TRINITY RANCH
PRE DEVELOPMENT GRADING AND EROSION CONTROL PLAN
A PORTION OF THE SOUTHEAST QUARTER OF SECTION 9, TOWNSHIP 14 SOUTH, RANGE 63
WEST OF THE SIXTH PRINCIPAL MERIDIAN, EL PASO COUNTY, STATE OF COLORADO

Add PCD File No. SP268

TRINITY RANCH
EL PASO COUNTY, COLORADO
PRE DEVELOPMENT GRADING AND
EROSION CONTROL PLAN
GEC COVER

TRINITY RANCH
EL PASO COUNTY, COLORADO
PRE DEVELOPMENT GRADING AND
EROSION CONTROL PLAN
INITIAL (1 OF 2)

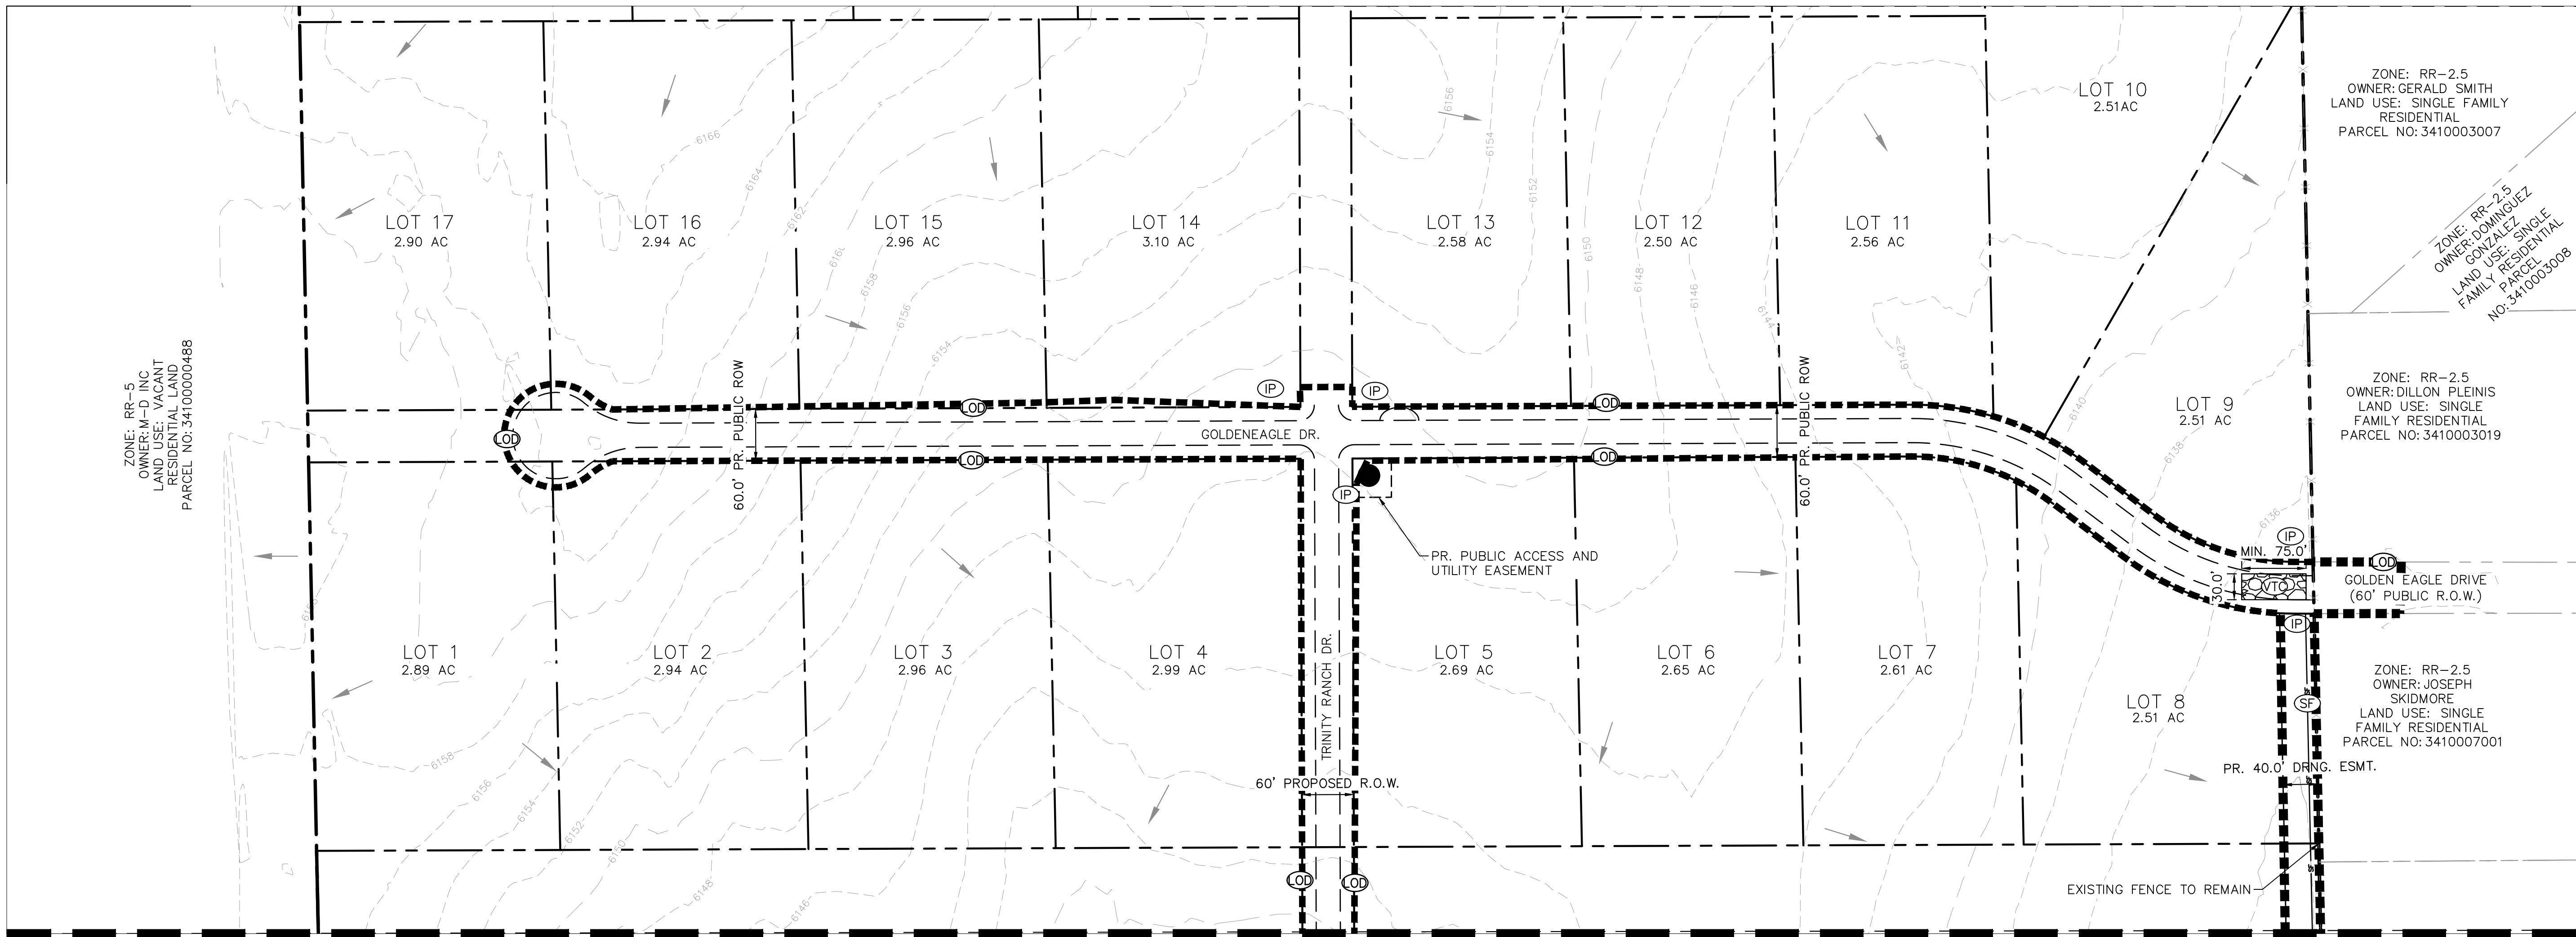
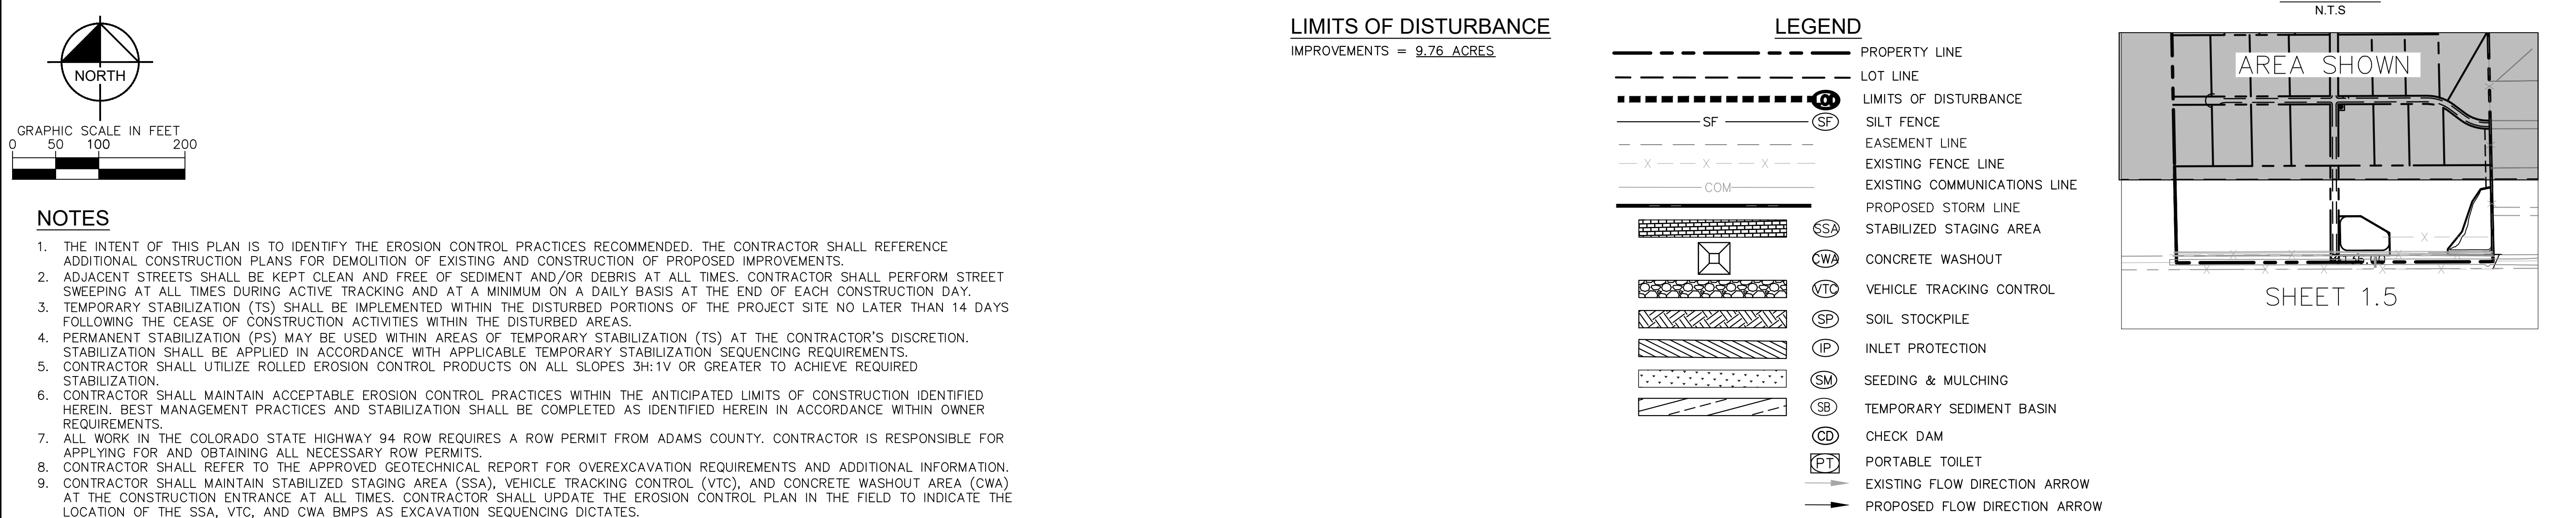
Show existing vegetation (a note is acceptable where there is no notable vegetation, only grasses/weeds)

If "limits of disturbance" and "construction boundary" are the same, change to "limits of construction/disturbance" or otherwise show as separate line types for each on the legend and figure.

TRINITY RANCH
EL PASO COUNTY, COLORADO
PRE DEVELOPMENT GRADING AND
EROSION CONTROL PLAN
FINAL (1 OF 2)

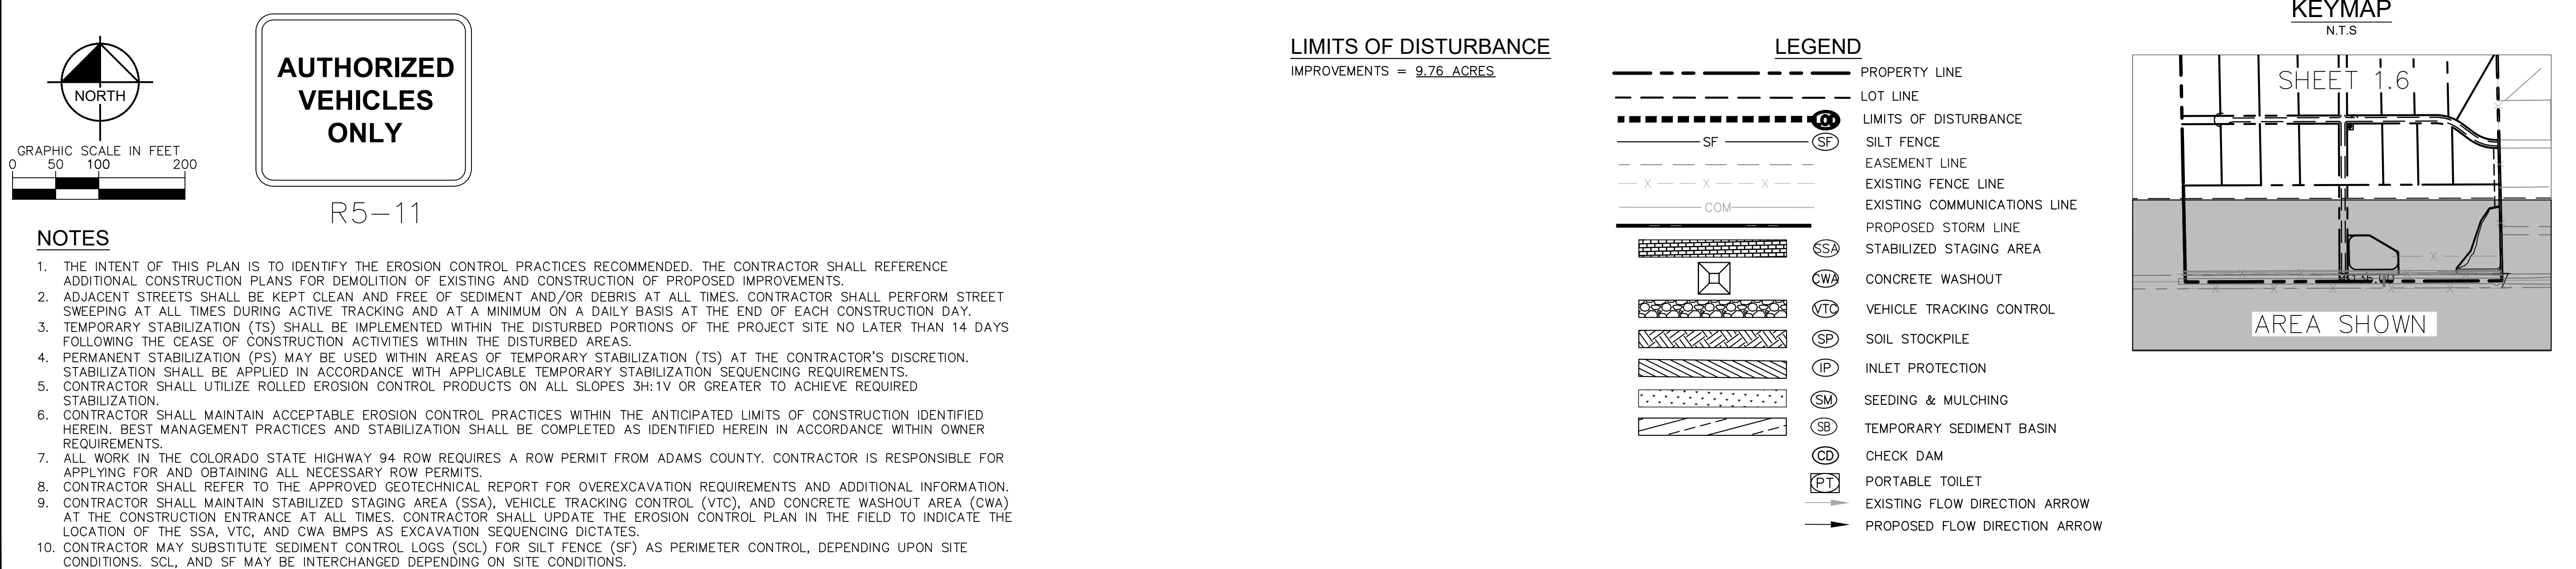
All temporary control measures should be shown as removed in the final condition. Grey out, remove from sheet, or add "remove" bubble to TCNs that should be removed. The exception to this would be the sediment basins that require the pipe to remain to prevent injury to downstream water rights.

If the final plat project follows the early grading project soon enough to share controls it will be specified on the final plat GEC plans.
